The Sizewell C Project

Natural England's Comments on the Water Monitoring Plan

Planning Inspectorate Reference: EN010012

Natural England's comments on Revision 1.0 Water Monitoring Plan [REP7-075]

DRAWING NO:
 FIGURE 19.3

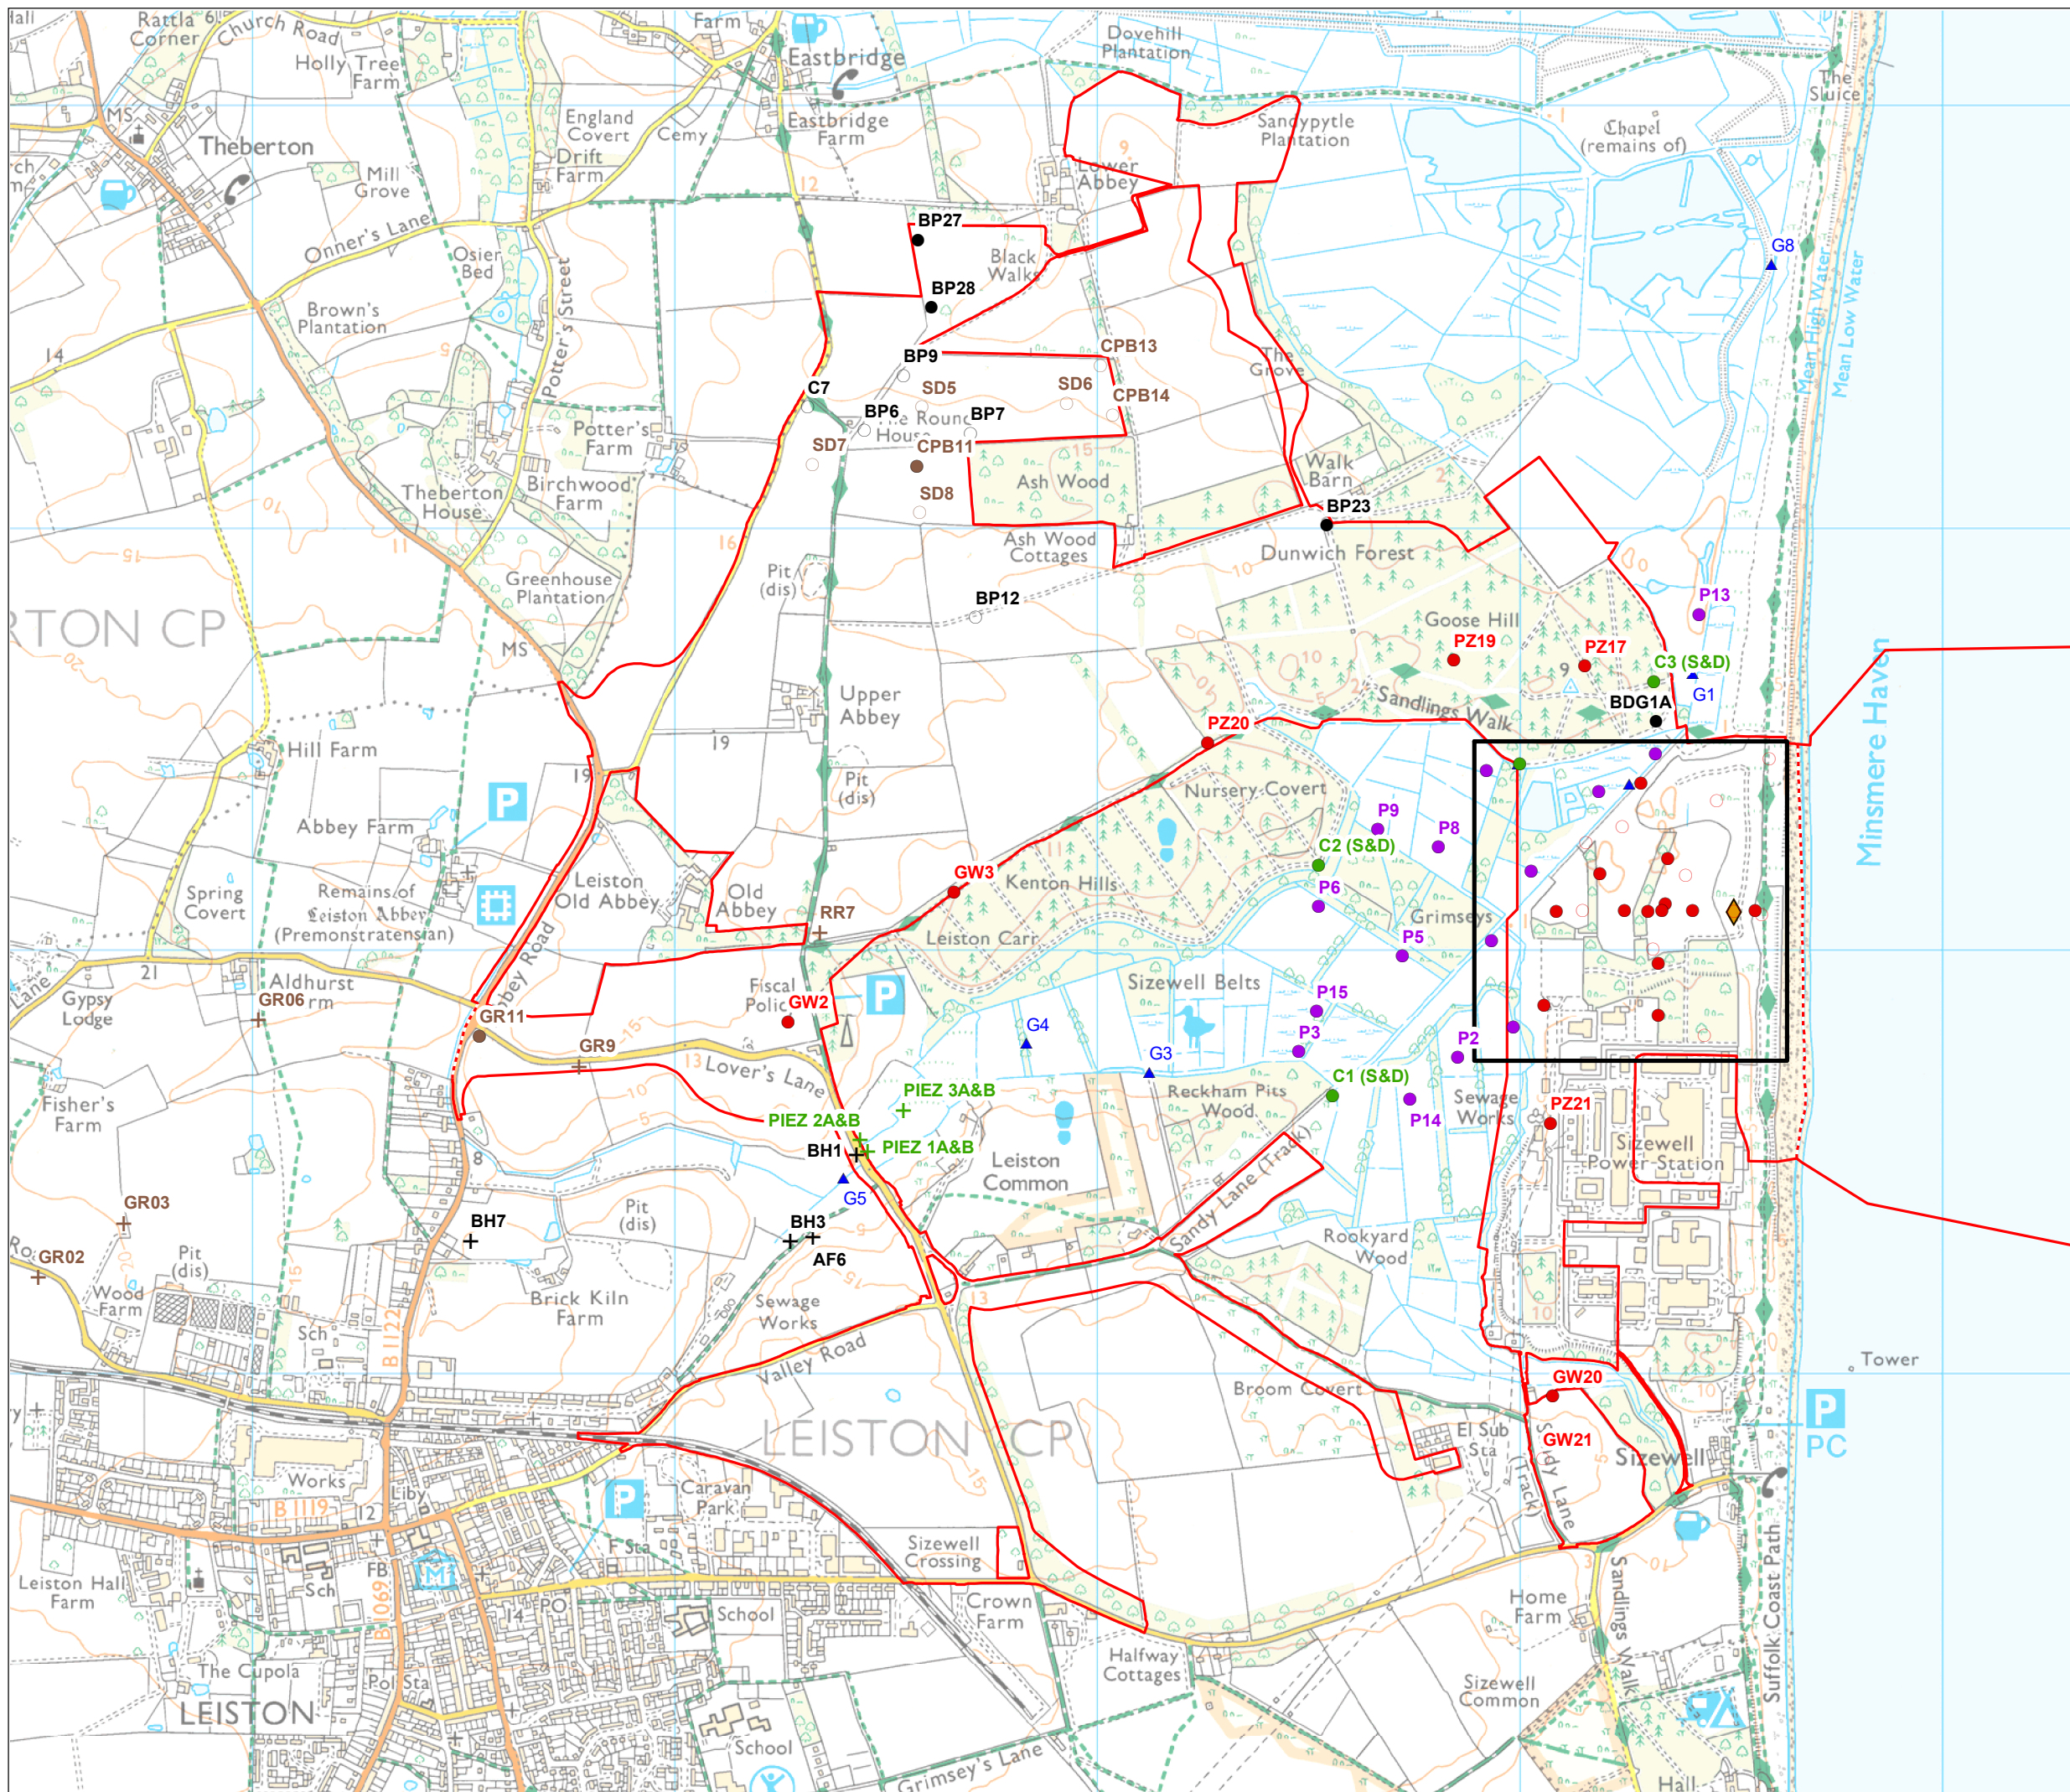
- 1.4 Trigger water levels have been derived for the P series of boreholes (Peat Piezometers) only, with a winter (Nov-Feb) minimum of the 30th percentile of baseline, and a summer (Mar-Oct) minimum of the 30th percentile and maximum of the 70th percentile of the baseline. No rationale has been presented for the selection of these apparently arbitrary threshold levels.

- 1.5 No trigger levels have been defined for the other boreholes (i.e. those monitoring geological horizons other than the peat) or the surface water monitoring locations. It would be beneficial to define how the monitoring from these locations would be used, especially in the event of greater-than-predicted effects being observed.
